WEST SUSSEX COUNTY COUNCIL CONSULTATION

TO:	Arun District Council FAO:David Easton
FROM:	WSCC - Highways Authority
DATE:	19 October 2021
LOCATION:	Oldlands Farm Cottages Steyning Way Bersted PO22 9NN
SUBJECT:	BE/145/21/DOC Approval of details reserved by condition imposed under ref BE/126/19/PL relating to Condition Nos 4 - hard & soft landscaping, 5 - pedestrian link/cycle link, 9 - Travel Plan and 13 - electric vehicle charging.
DATE OF SITE VISIT:	n/a
RECOMMENDATION:	Advice
S106 CONTRIBUTION TOTAL:	n/a

3 Charging Foundation 3D

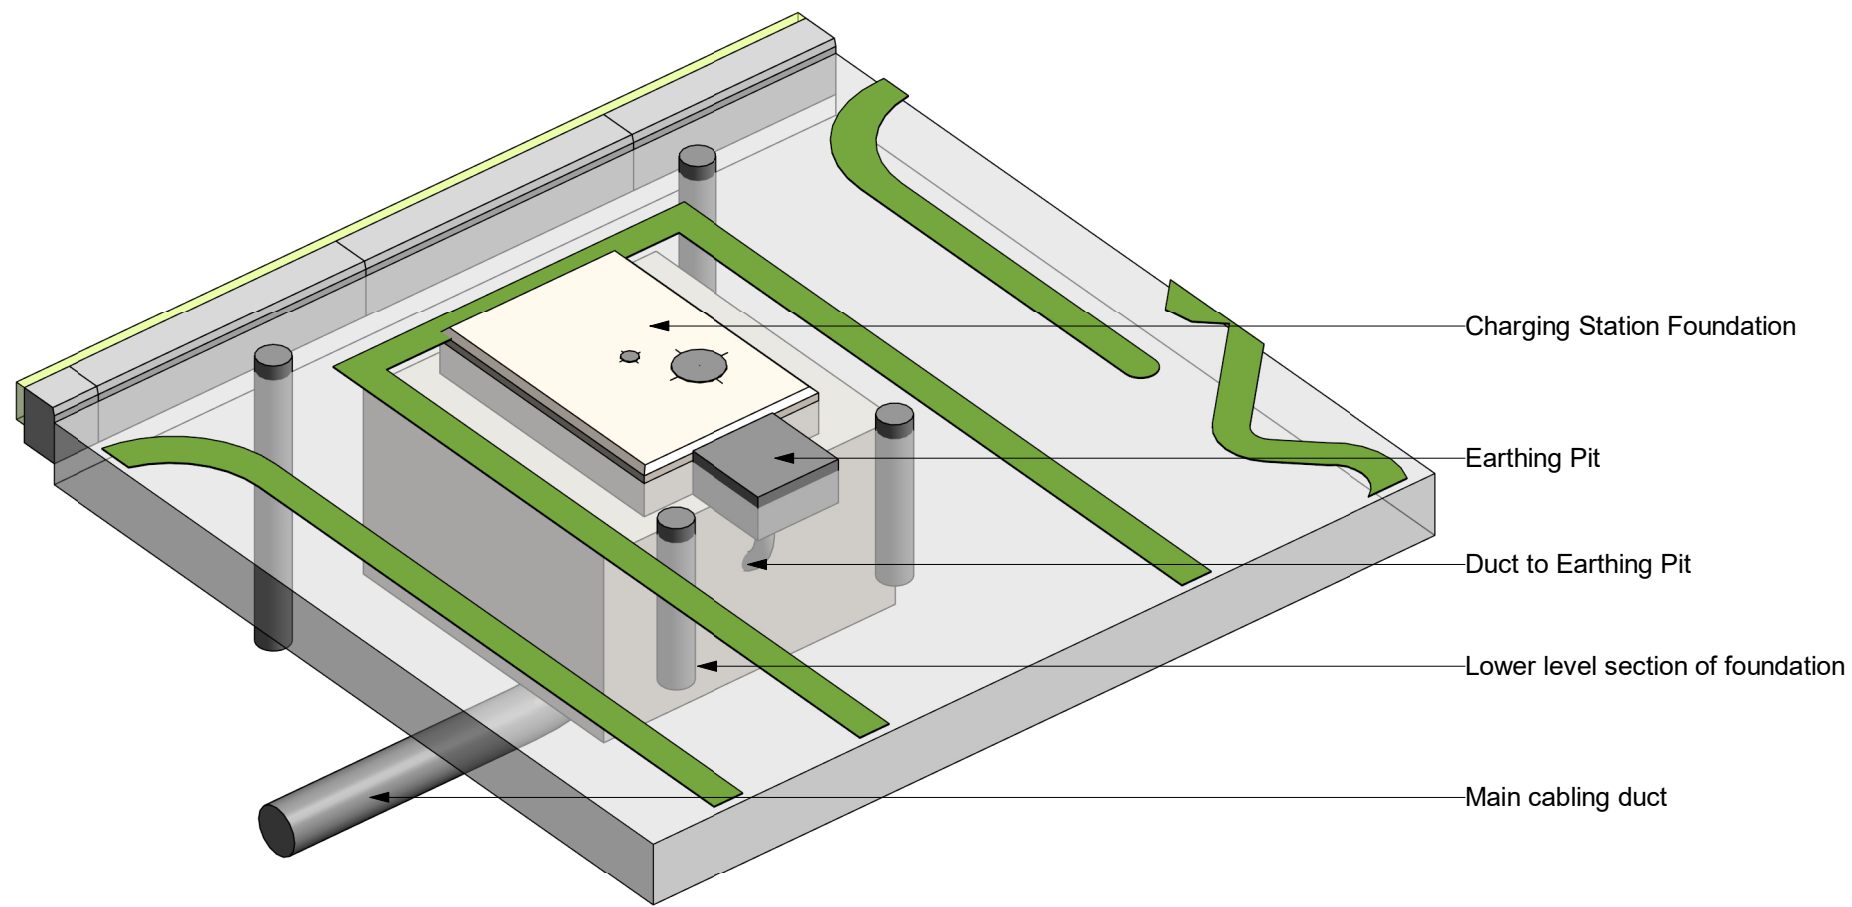
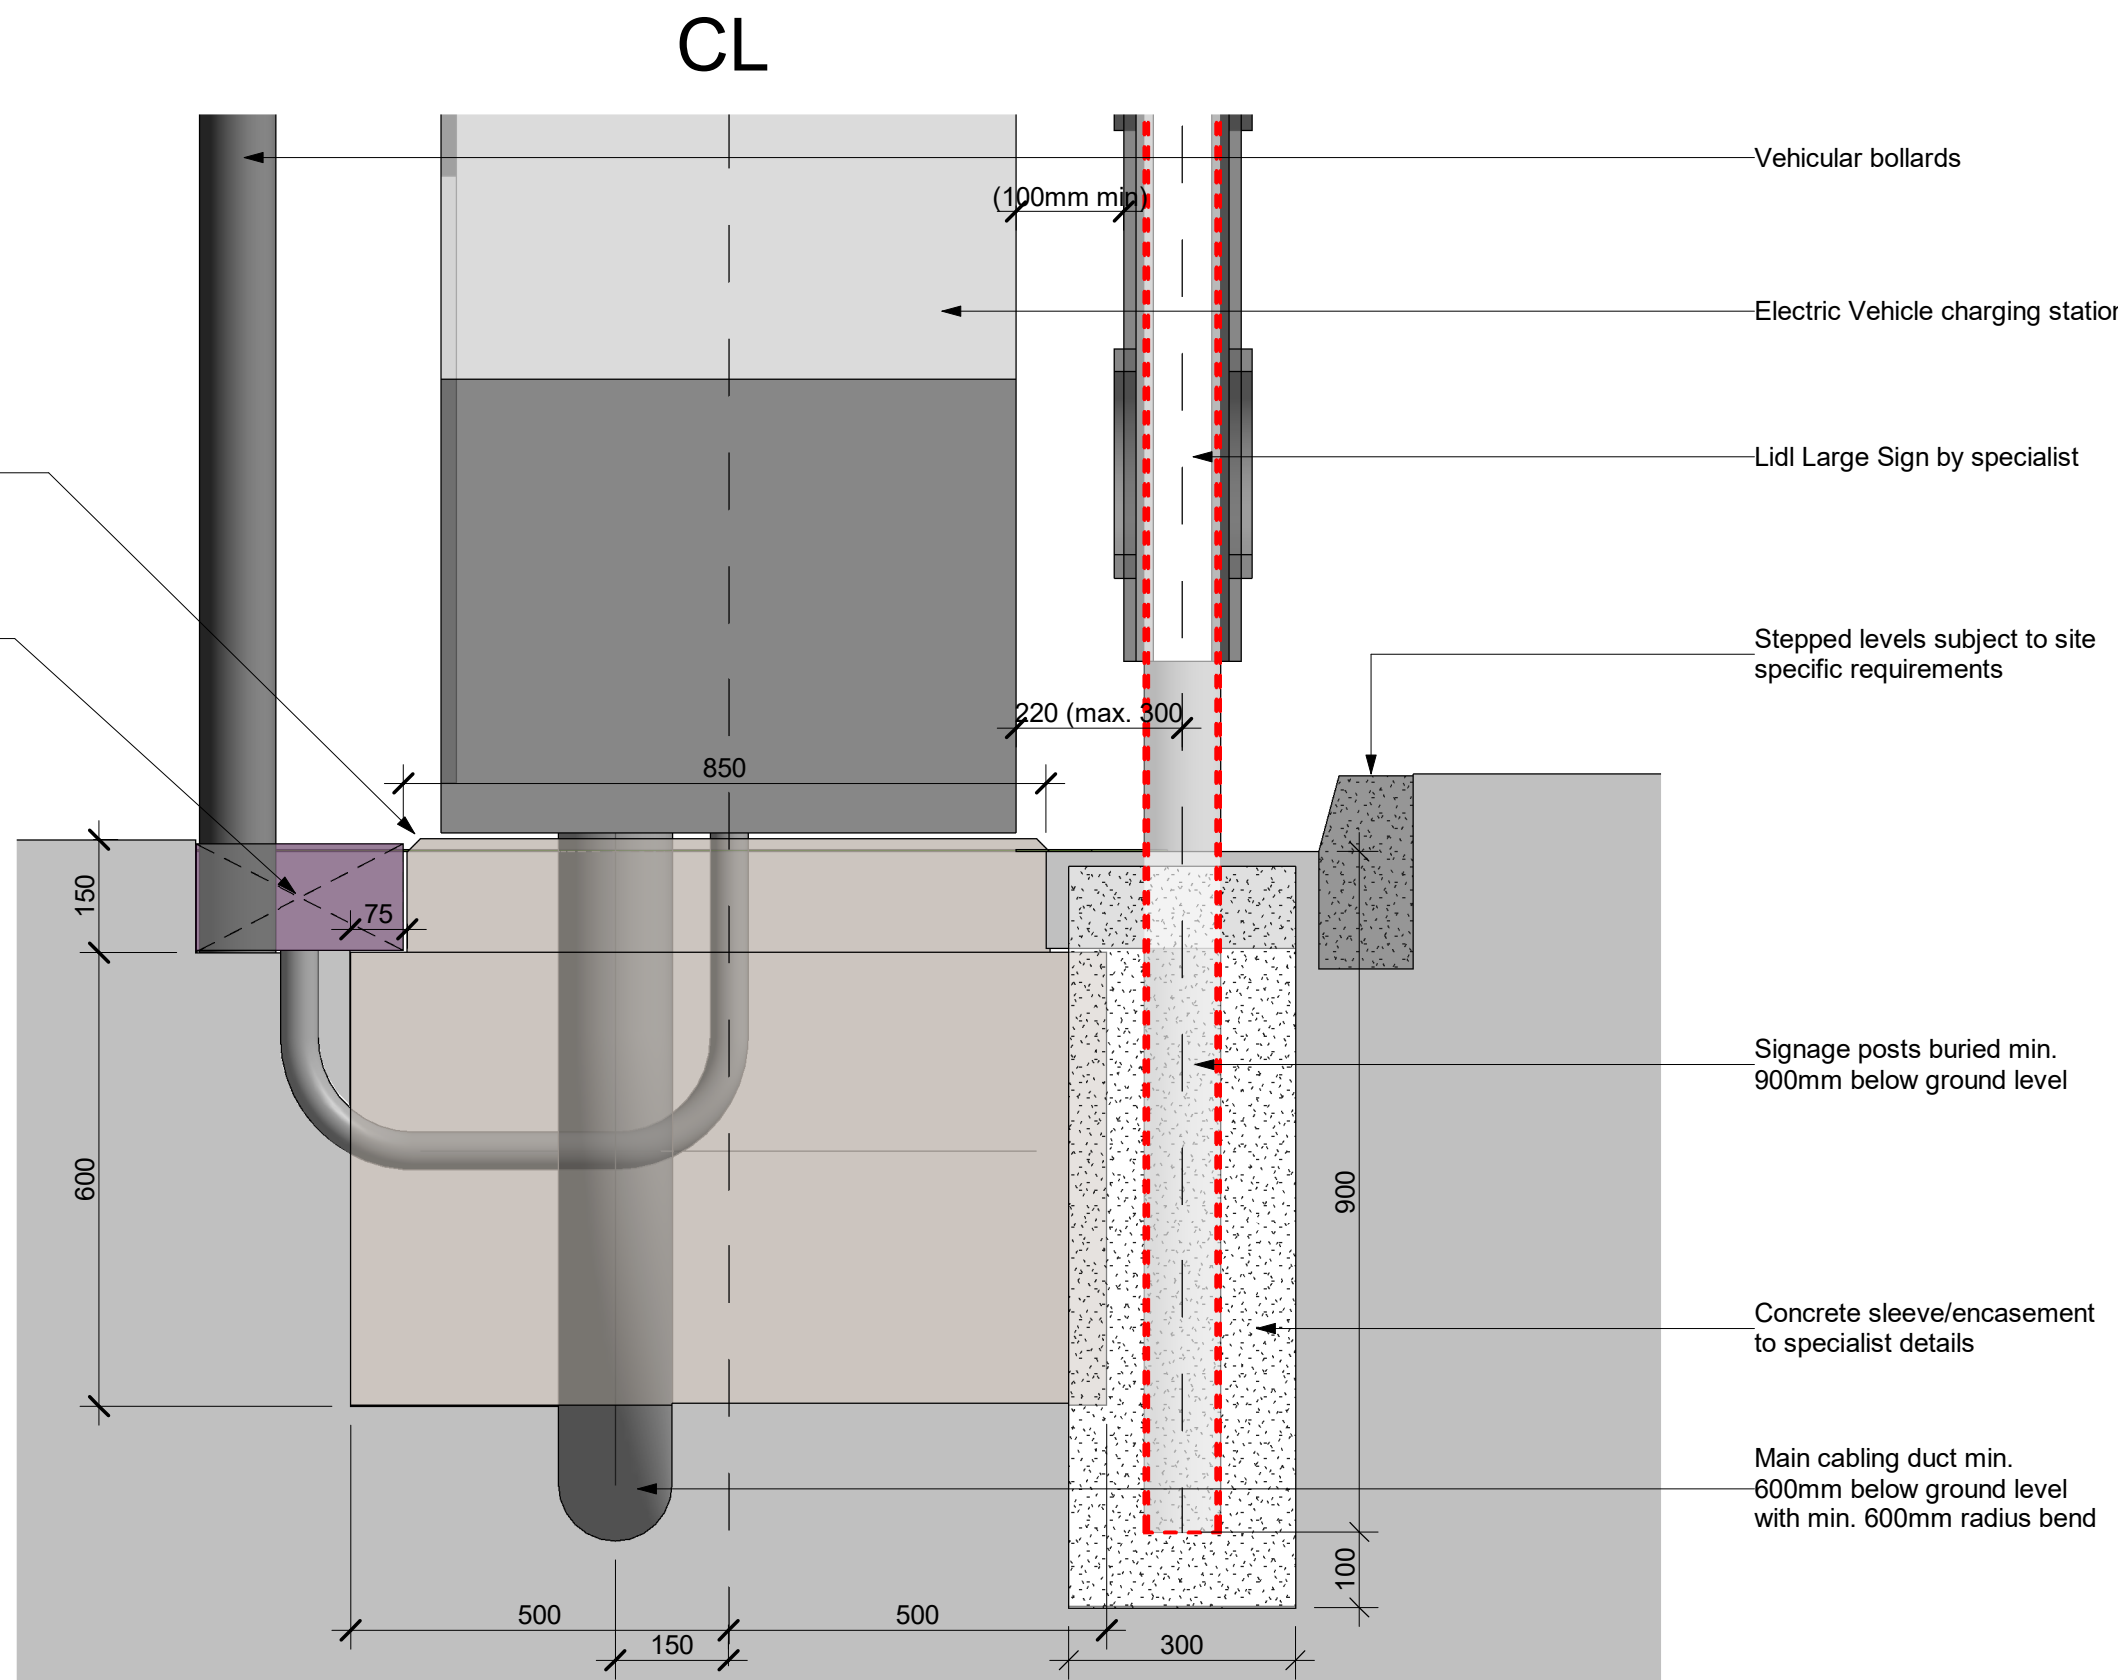
Condition 13-The LHA would be satisfied with the proposed allocation of Electric Vehicle charging points at the site.
